## Determination Report

**Determination of Section 75W Modification Application to the Project Approval for a Mixed Use Retail and Residential Development at 23-41 Lindfield Avenue and 7 & 11 Havilah Lane, Lindfield (MP08\_0244 MOD 3)**

1 SHADOW DIAGRAM - 21stJUNE\_9AM  
5001 NOT TO SCALE

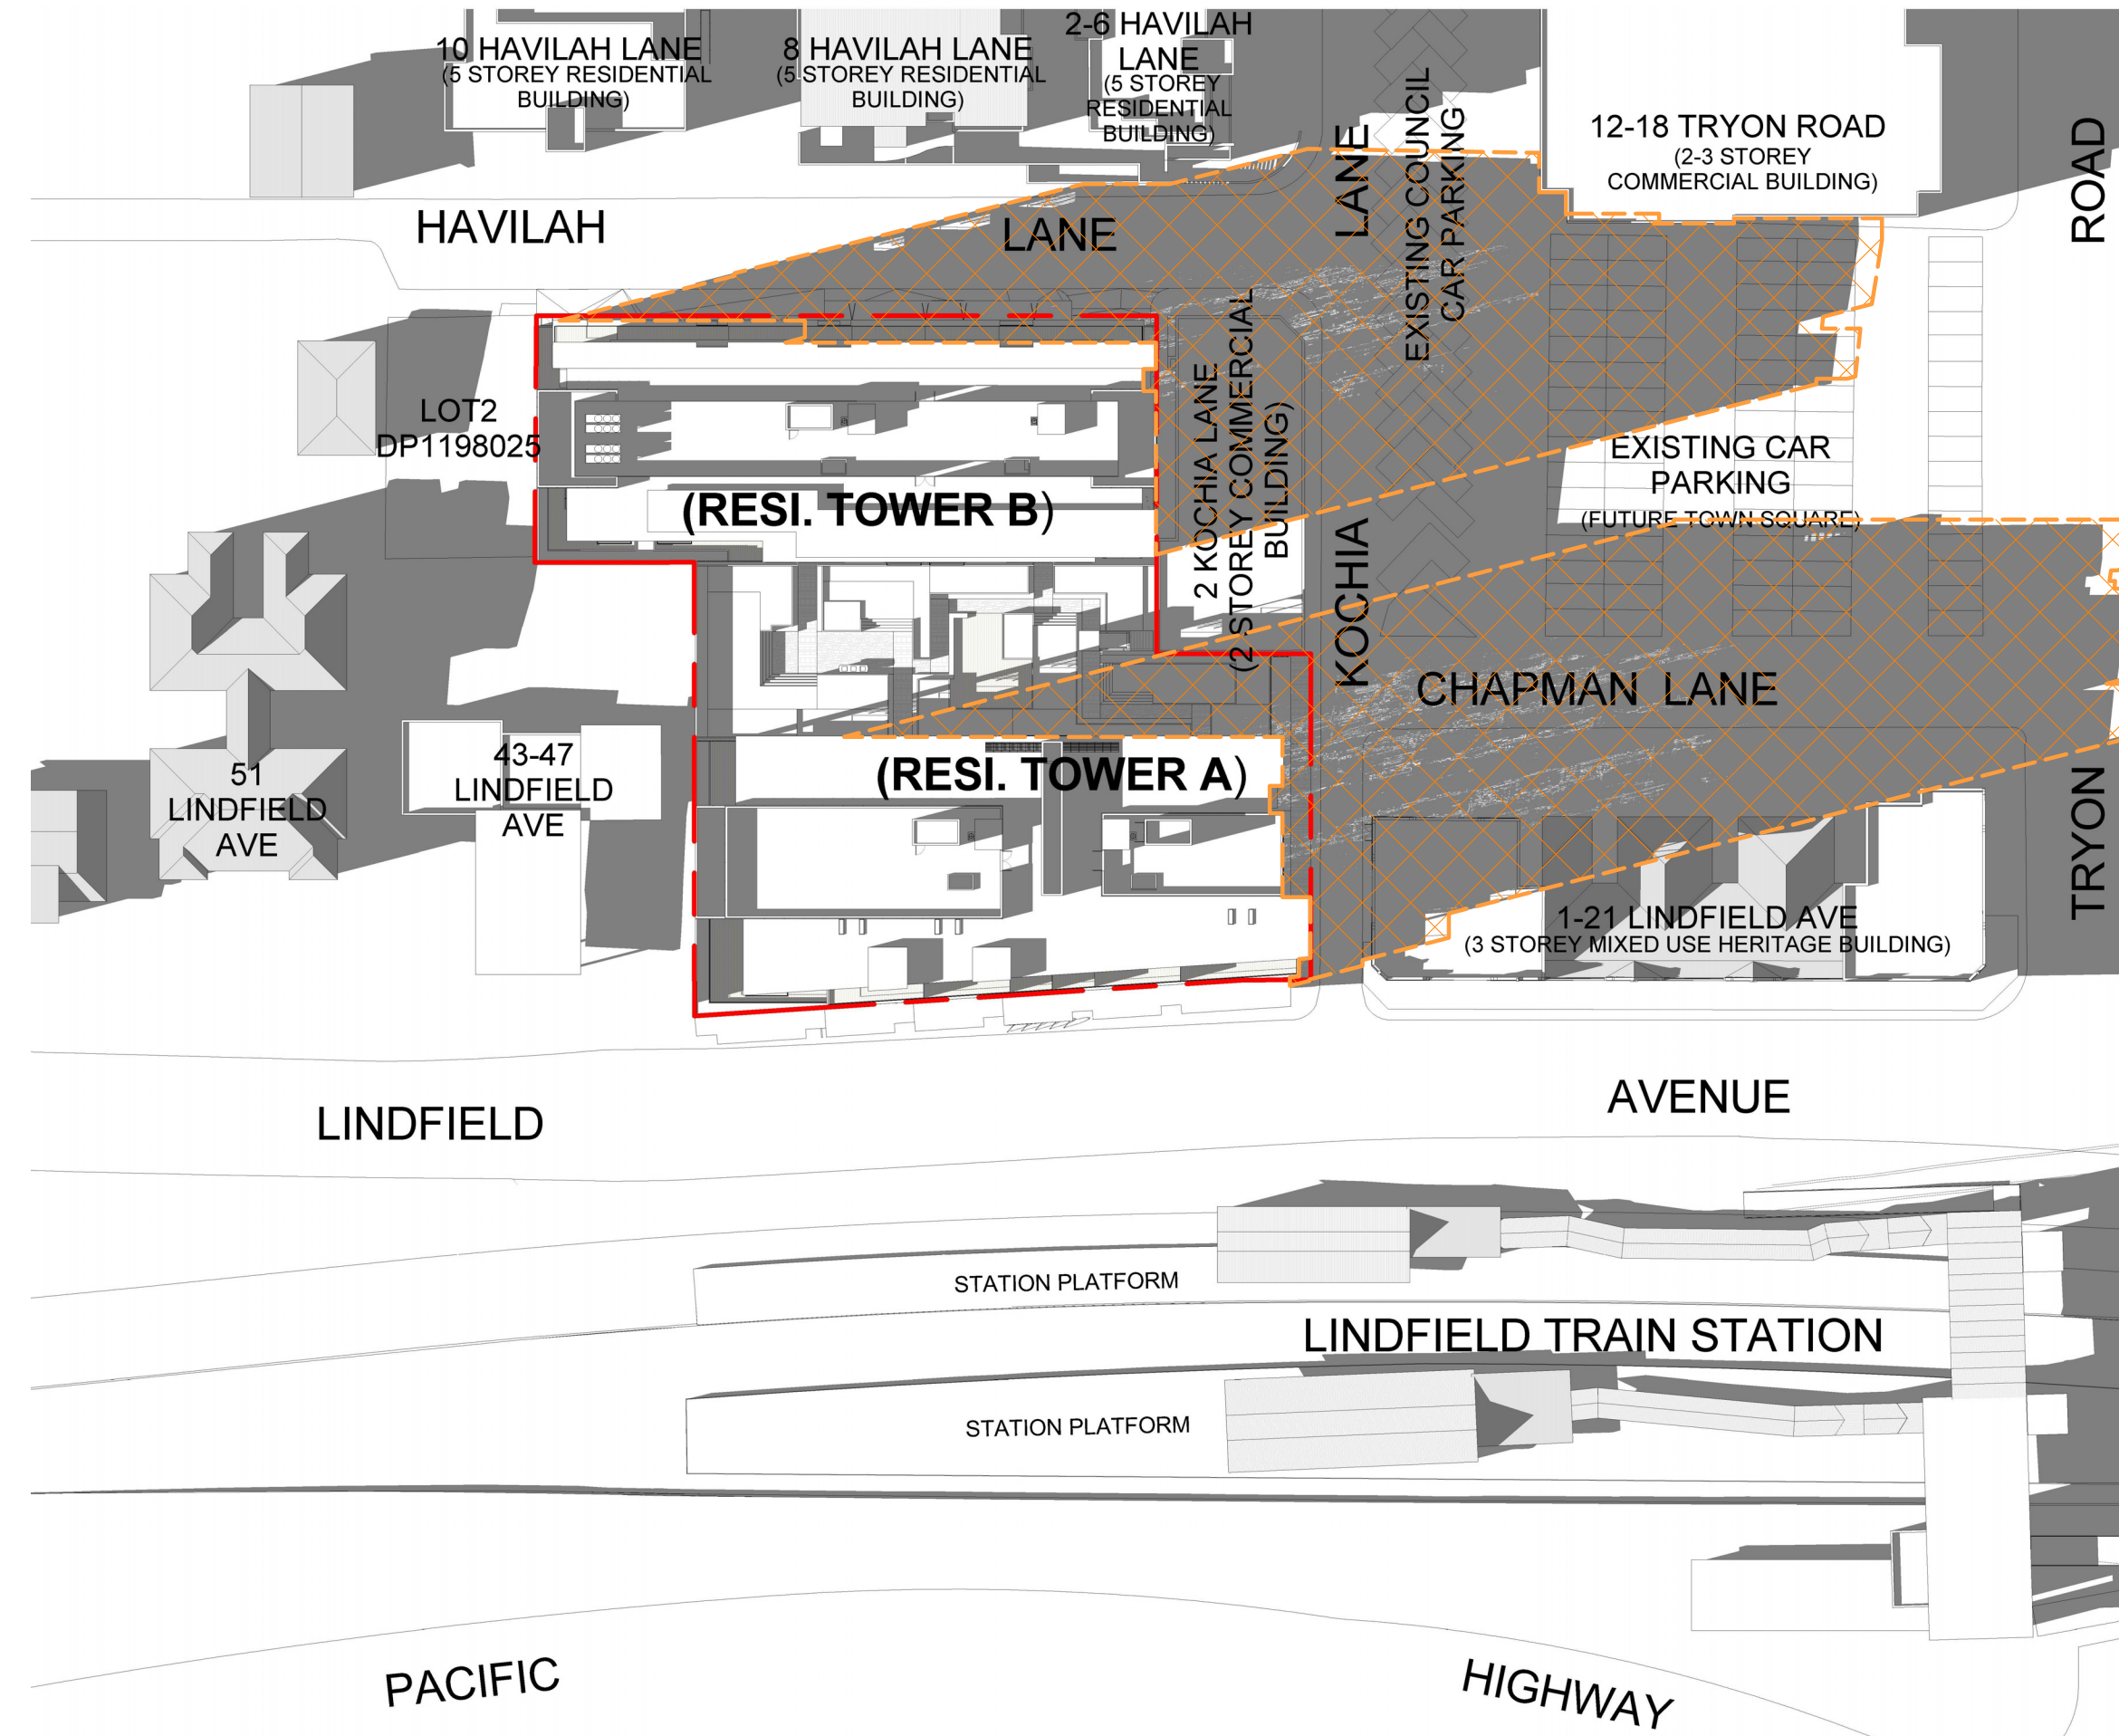
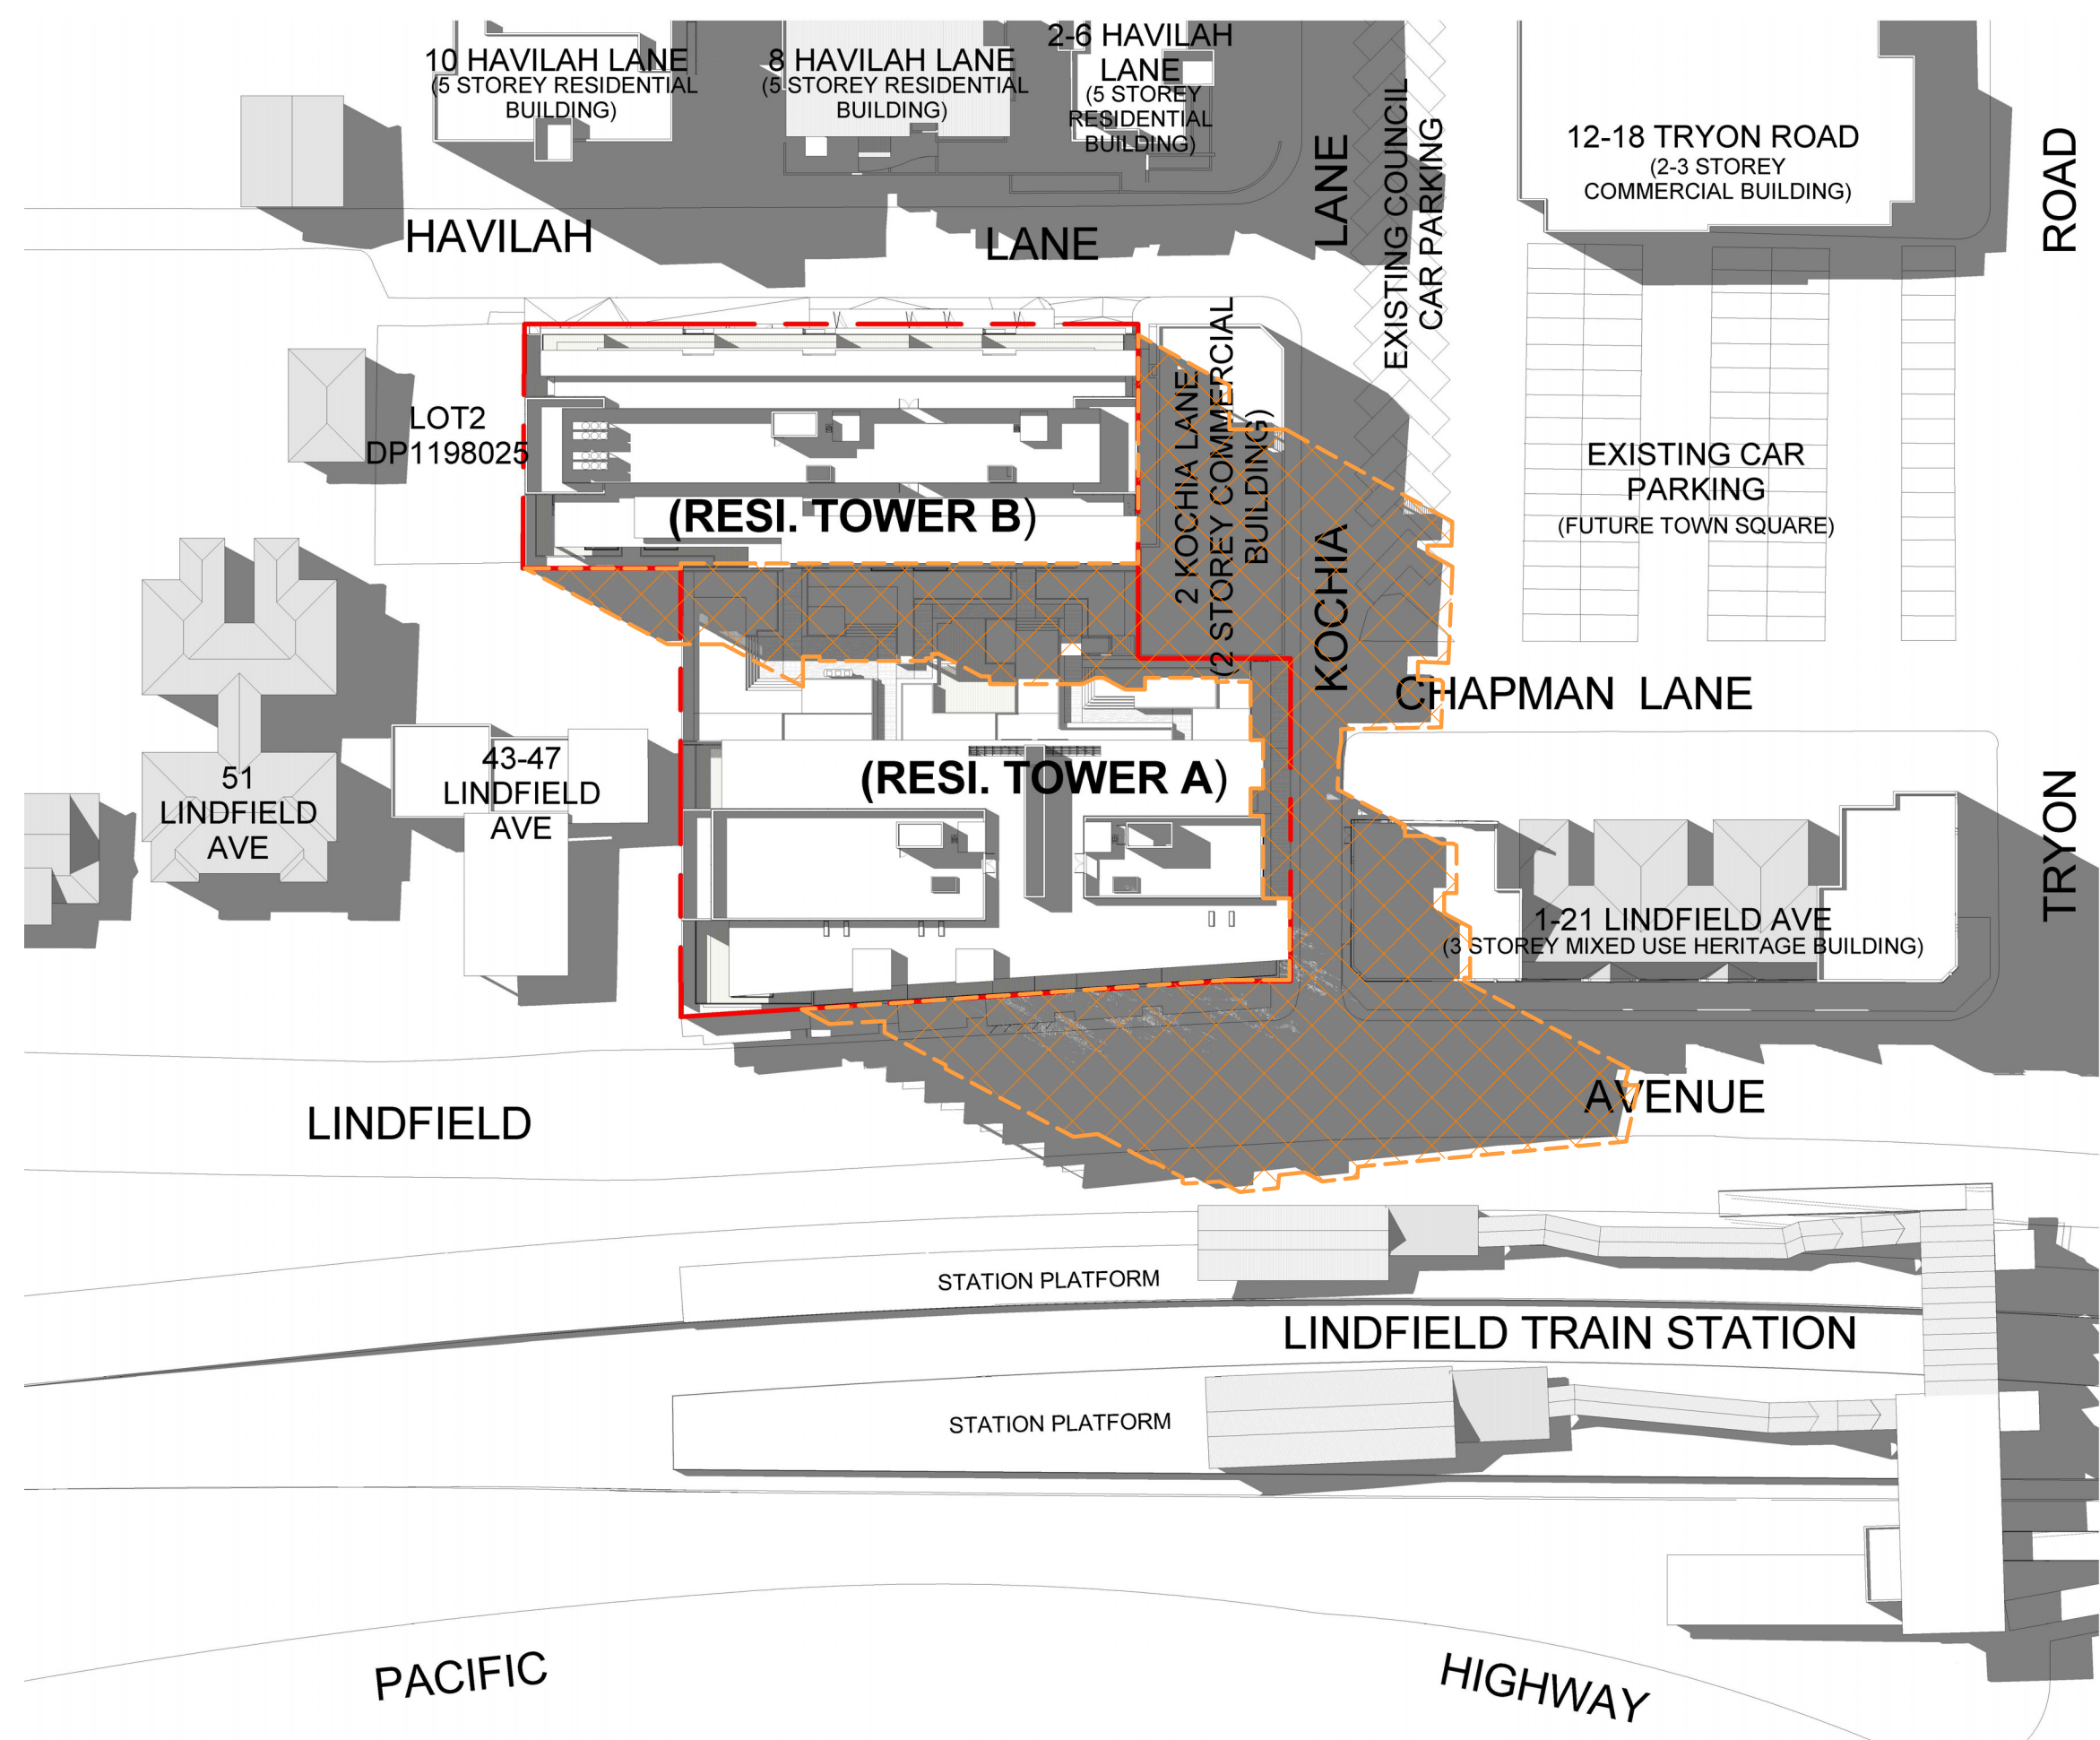
The Residential Flat Design Code (RFDC) and the Apartment Design Guide (ADG) recommend that a minimum of 70% of apartments receive at least two hours of sunlight during the winter solstice to **both** living areas and private open space. It is noted that the existing Project Approval does not achieve the recommended 70% for minimum solar access during the winter solstice months. However, the Project Approval does provide two hours of sunlight during winter solstice to the living area **and/or** private open space for 72% of apartments.

The Commission requested further information from both the Department and the Proponent regarding the assessment of solar access for the proposed additional 19 apartments. The Commission requested that the solar access assessment be based on two hours of sunlight during winter solstice for **both** the living area and private open space.

The Proponent informed the Commission that 49.2% of the apartments in Modification 2 would have achieved the minimum solar access during the winter solstice months, and only 46.8% would achieve the minimum solar access in Modification 3. As a result, the Commission requested that the Proponent investigate and propose design options to improve solar access.

In response to the Commission's request, the Proponent provided amended plans including the addition of seven skylights and advised that *'the amendments improve overall solar access compliance from Mod 2 taking the figures from 49.2% to 51.8%'* (including the effects of the development adjacent on 43-47 Lindfield Avenue). The amendment to the plans improved the solar access afforded to seven apartments that were not able to achieve the minimum solar access during the winter solstice months. While the RFDC and ADG guidelines are silent on the use of skylights in satisfying solar access requirements, the Commission considers the skylights would improve the amenity for future residents.

The Commission is satisfied that the Proponent has provided an improved amenity outcome for the development through the inclusion of seven skylights which has resulted in increased solar access for seven apartments.
